Rezoning Petition Review

Date of Review: July 27, 2020 (***Revised August 31, 2020***)

Rezoning Petition #: 20-74

Location of Property: Approximately 21.08 acres located along the south side of Harris Houston Rd, north of University City Blvd and east of I-485.

SHEET TITLE:
CONDITIONAL REZONING: CONCEPTUAL SITE PLAN
SHEET NUMBER:
RZ1.0

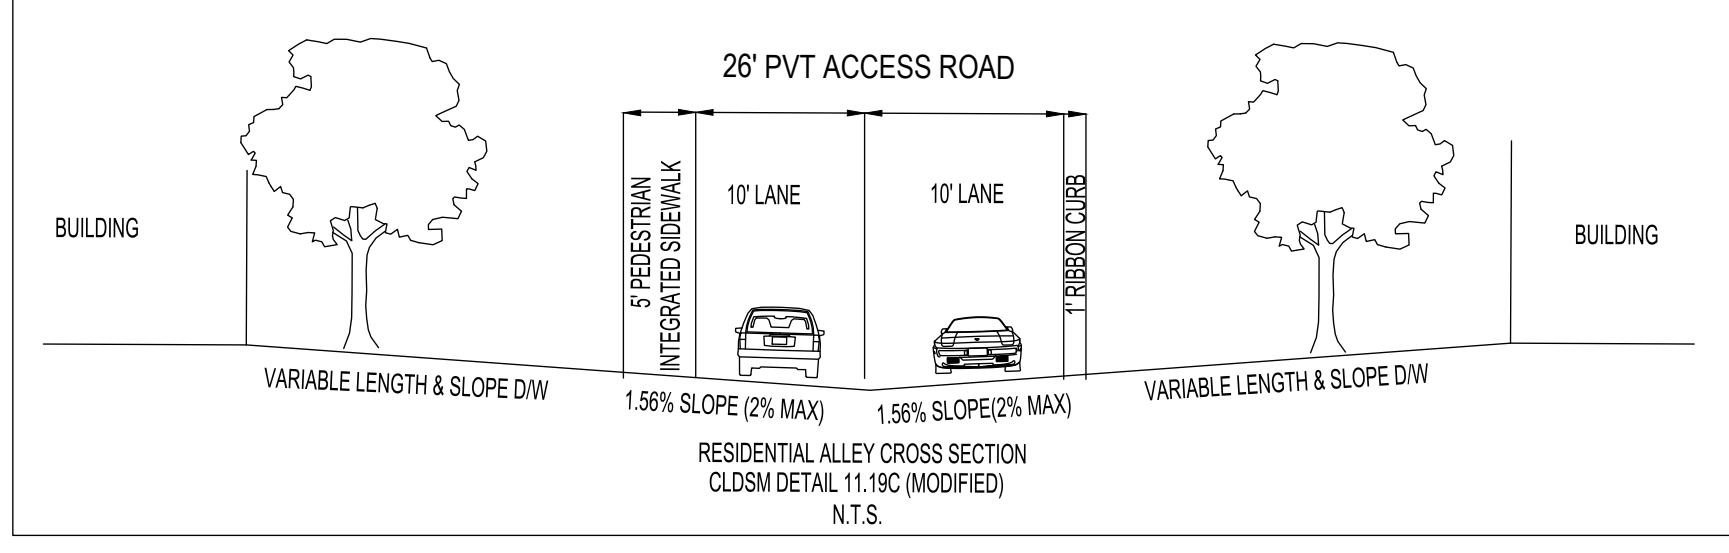
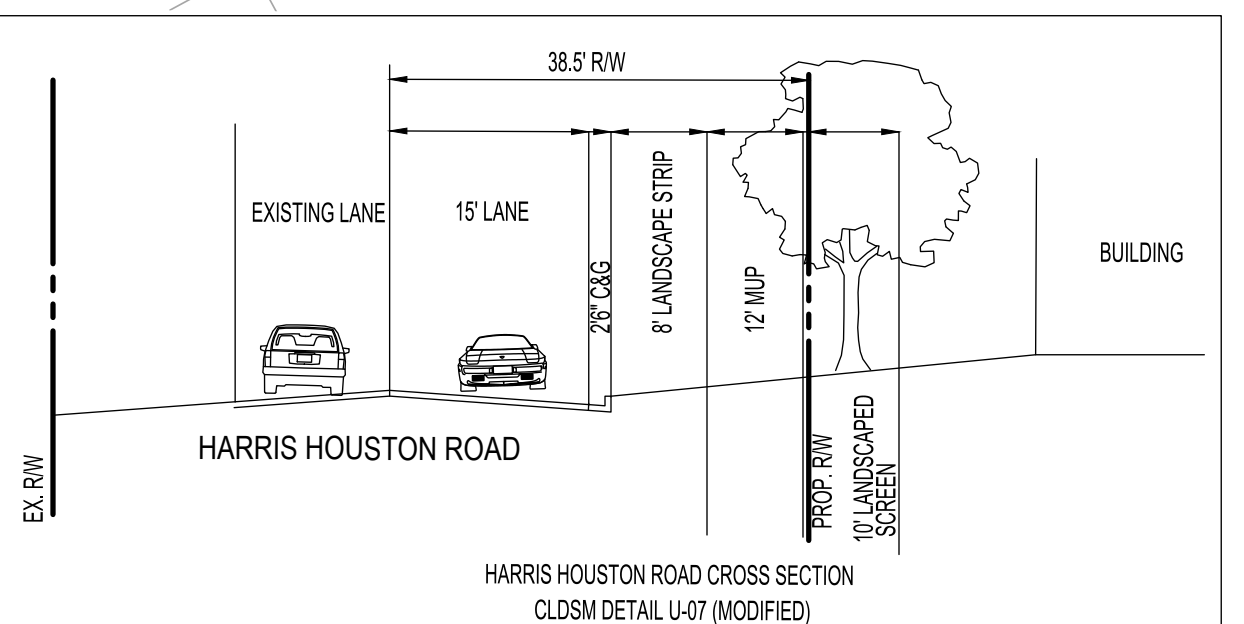
Concerning Storm Water: Plan sheet RZ-1 indicates a 100-ft Post Construction Stormwater Ordinance Buffer on site. Please revise buffer label to read “100-ft Undisturbed PCSO Buffer.”

The rezoning plan proposes several encroachments into SWIM and/or Post Construction Stormwater Ordinance stream buffers. Any increase of impervious area within such buffers may not be allowed and is not approved with the rezoning process. Please include the following note under Environmental Features: “*Development within the SWIM/PCSO Buffer shall be coordinated with and subject to approval by Charlotte-Mecklenburg Storm Water Services and mitigated if required by City ordinance.*” Please note Stream Delineation Reports are subject to review and approval by Charlotte Storm Water Services.

Due to revisions (8/31/20): No additional recommendations are needed at this time.
